Please ask for: Sian Eggington
Email: sian.eggington@terraquest.co.uk
Telephone: 0121 2341390
Our Ref: R/142/20/HH
Your Ref:
Date: 12th August 2020

Application for Planning Permission for Works or Extension to a Dwelling

Development: Dropped Kerb for off road parking at front of property.
Location: 61 Worthing Road Rustington BN16 3JU

61 WORTHING ROAD

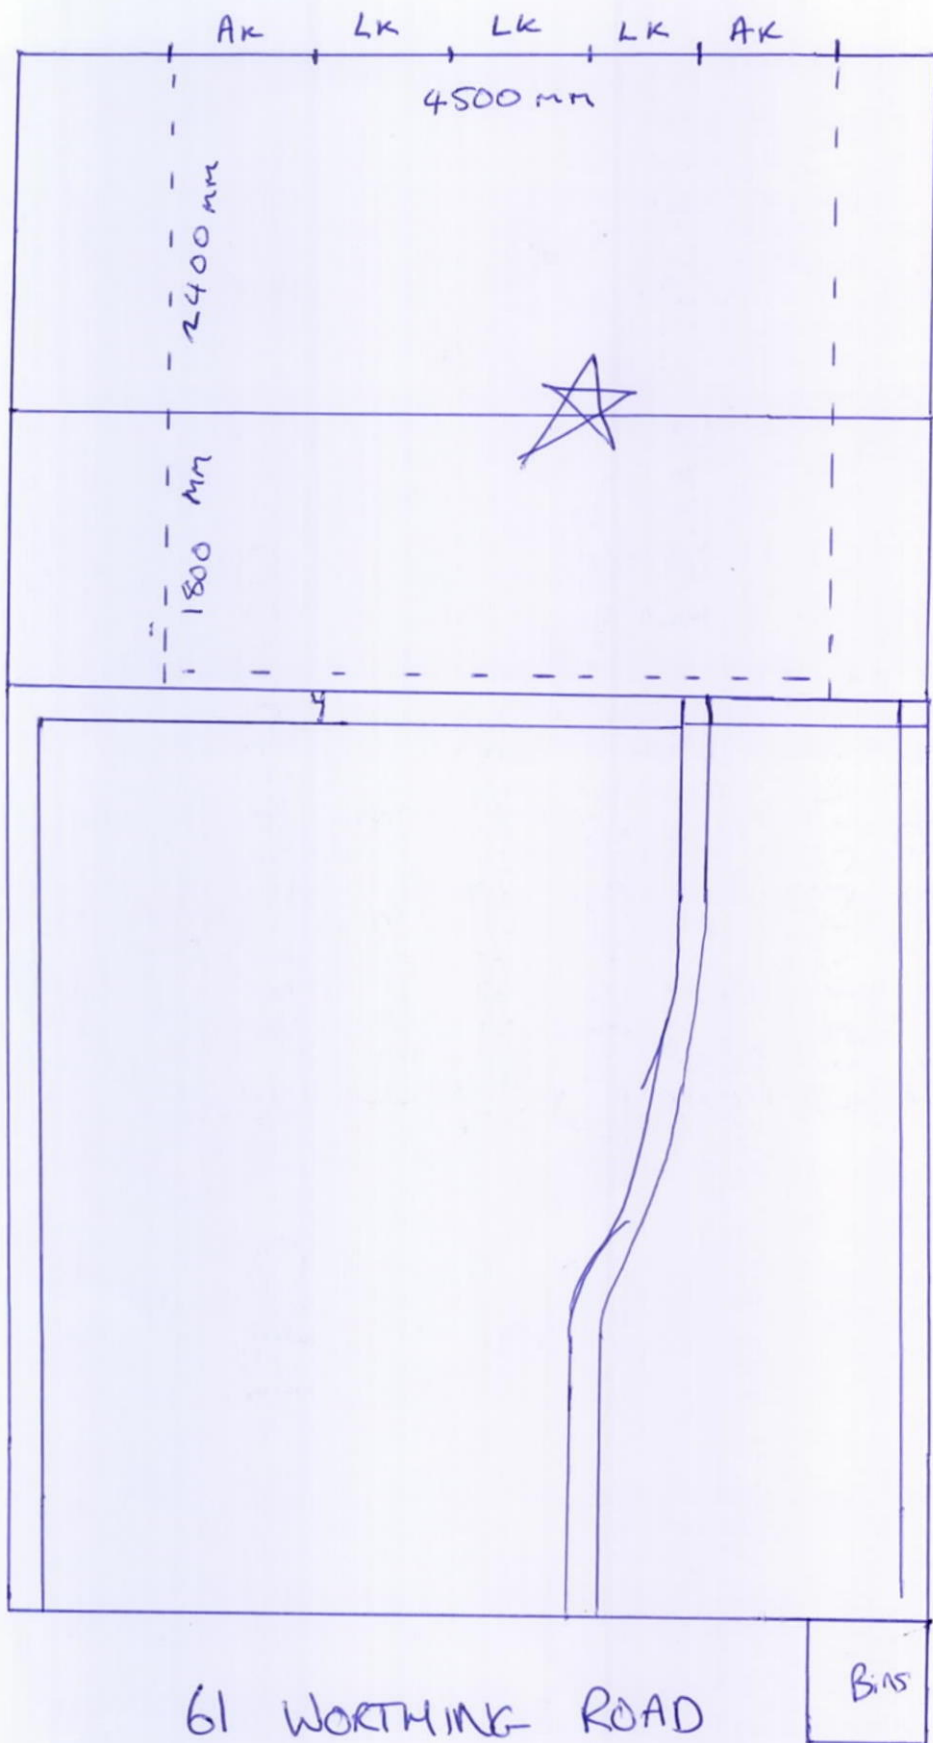
Crossover: Please provide a scaled plan of the proposed crossover. Please submit this at a scale of 1:50 or 1:100. With a scale bar or dimensions to allow for confirmation of stated scale.

West Sussex County Council require that a visibility splay is provided. A splay is formed for a 30 mph speed limit road by measuring from a point 2.4m back from the kerb edge in the centre of the proposed access. A line should then be drawn from either side of this point for 43 m in each direction to the nearside edge of the carriage way. The splays must intersect land only within the control of the applicant, or within the publicly maintained highway.
